**STAR CITY CASINO MULTI-USE ENTERTAINMENT FACILITY
PYRMONT**

Reference is made to the Department of Planning's letter dated 5 November 2010 (Reference: MP 08_0098 MOD 7), concerning the abovementioned application which was referred to the Roads and Traffic Authority (RTA) for comment.

The RTA has reviewed the proposed modifications to the approved Star City Ballroom and associated works, and advises that the proposed development does not result in a significant traffic impact on the classified road network in addition to the previously approved development (to which the RTA's response dated 8 October 2008 applies).

Drawing Title  
**Loading Dock Heavy Vehicle Turning Paths**

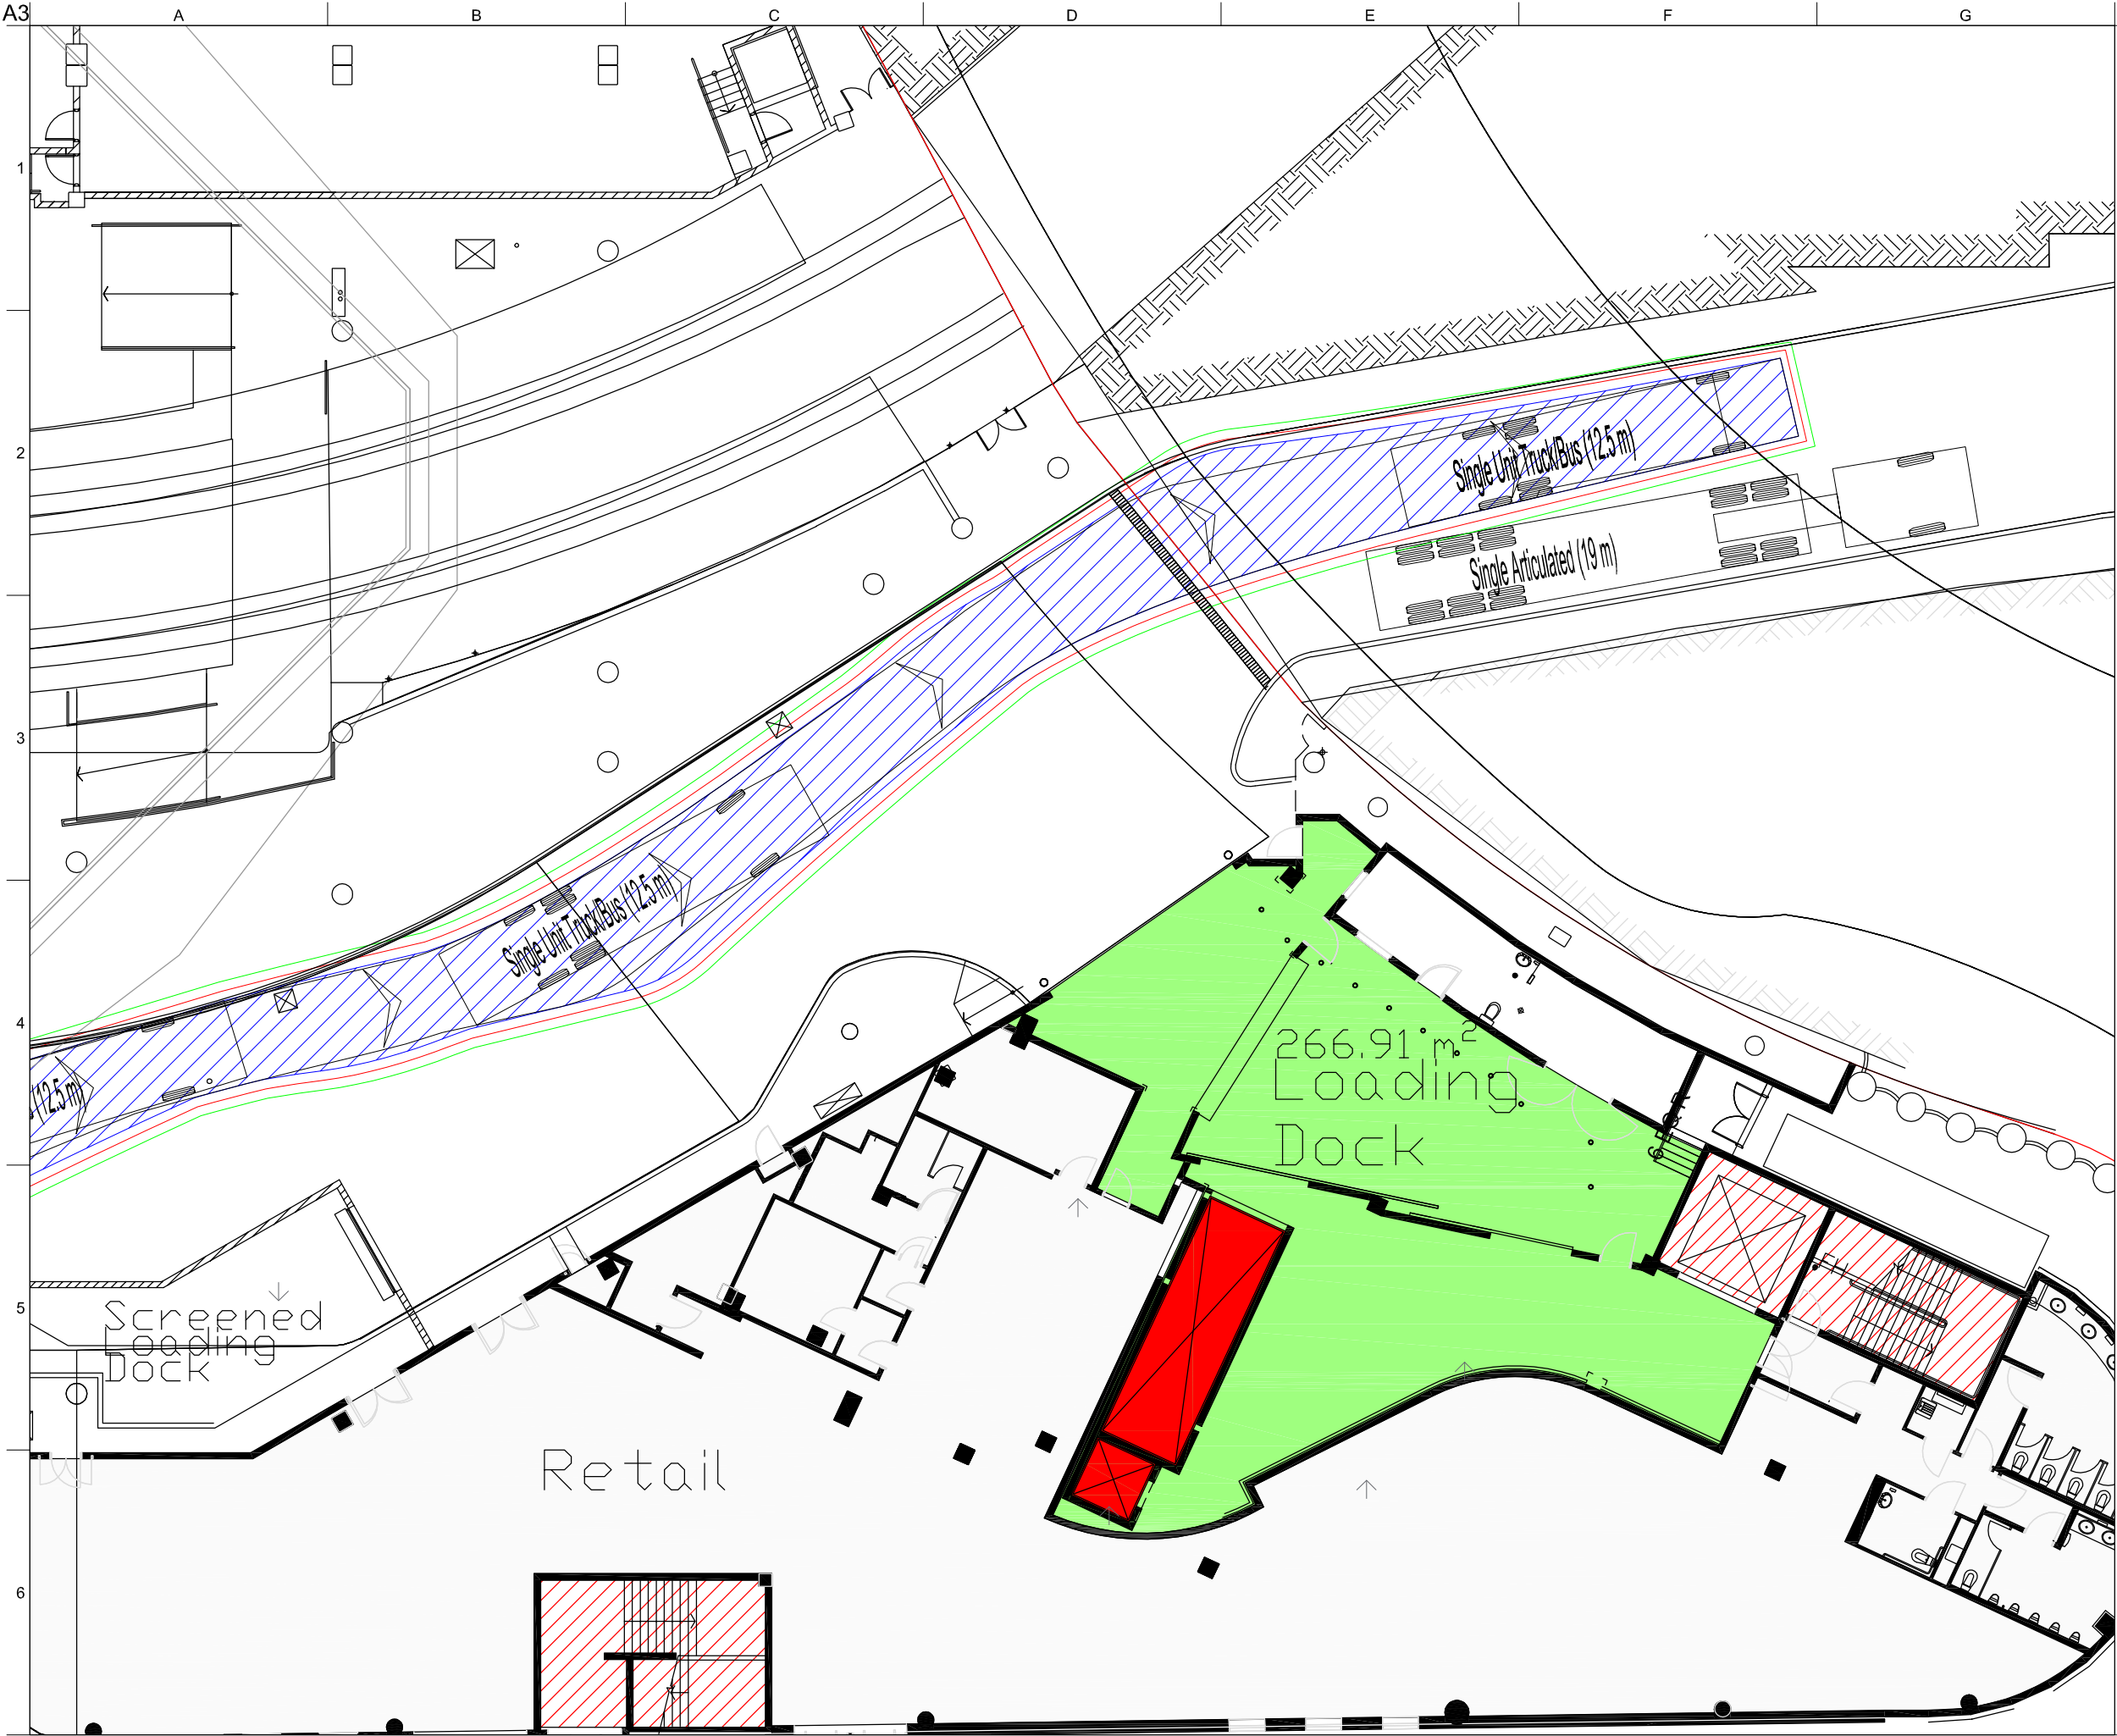
1. The plans submitted for the subject modification (7) do not provide adequate details of the proposed loading areas and compliance of these areas with AS 2890.2 – 2002 for heavy vehicles or AUSTROADS requirements for vehicle swept paths.
2. The swept path of the longest vehicle (including garbage trucks) entering and exiting the subject site, as well as manoeuvrability through the site shall be in accordance with AUSTROADS. Swept path plans which illustrate compliance with this requirement shall be submitted to the Department of Planning for approval.
3. The layout of the vehicle accessible areas associated with the subject development (including: driveways, grades, aisle widths, turning paths, sight distance requirements, and parking bay dimensions) shall be in accordance with AS 2890.1-2004 and AS 2890.2 – 2002 for heavy vehicles.
